## PLANNING CONSULTATION RESPONSE

<b>Application No</b>	2025/0583
<b>Proposal</b>	2025 0583 Erection of Detached Two Storey Dwelling Land Adj St John The Evangelist Carlton
<b>Address</b>	Land Adj St John The Evangelist Carlton
<b>Date of Consultation Reply</b>	060825
<b>Consultee</b>	Tony Wiles Senior Conservation Officer

PROPOSED BOUNDARY TREATMENTS

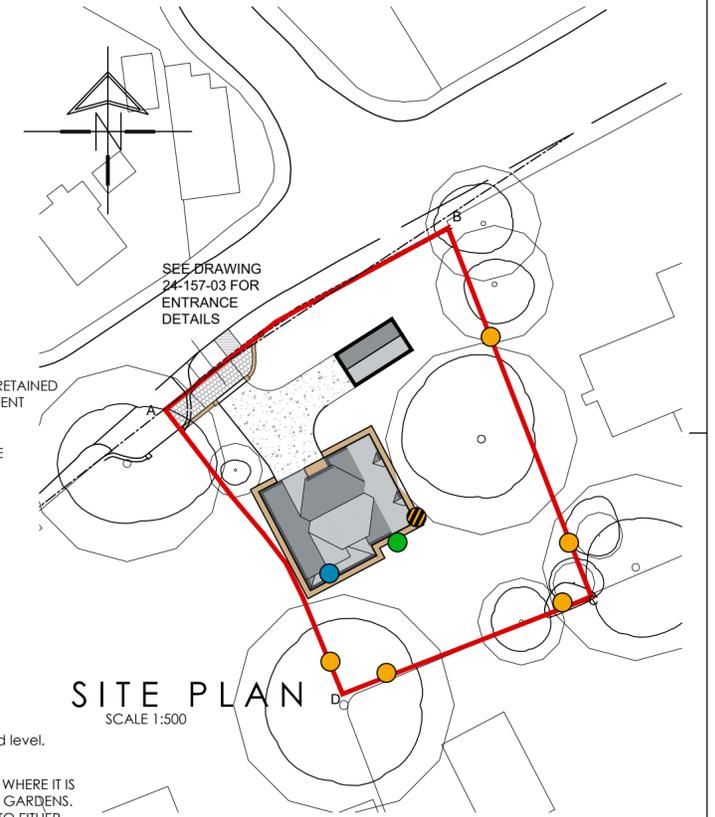
In terms of the site boundaries, a feather edged 1800 timber screen with concrete posts is proposed. This appears extremely modern and utilitarian and is not especially sympathetic, particular in terms of the eastern boundary and the church setting. This could easily be softened with other materials and fence types that compliment the setting more effectively. I also feel the eastern boundary should be supplemented with native planting including shrubs and trees that enhance the screen between the plot and the church to the east.

<b>No objections</b>		
*Delete as applicable		
<b><u>Consultation Suggested Conditions:</u></b>		
<ul style="list-style-type: none"><li>External materials shall match those in the immediate vicinity including materials used on the grade II The Gables and St Johns Church. No construction work will commence (or on commencement of works) a representative sample of all new external materials shall be submitted to, and approved in writing by, the Local Planning Authority, and the development shall proceed in strict accordance with these details as approved.</li></ul>		
<b><u>Consultation Informative(s):</u></b>		
<b><u>Planning Obligations required:</u></b>
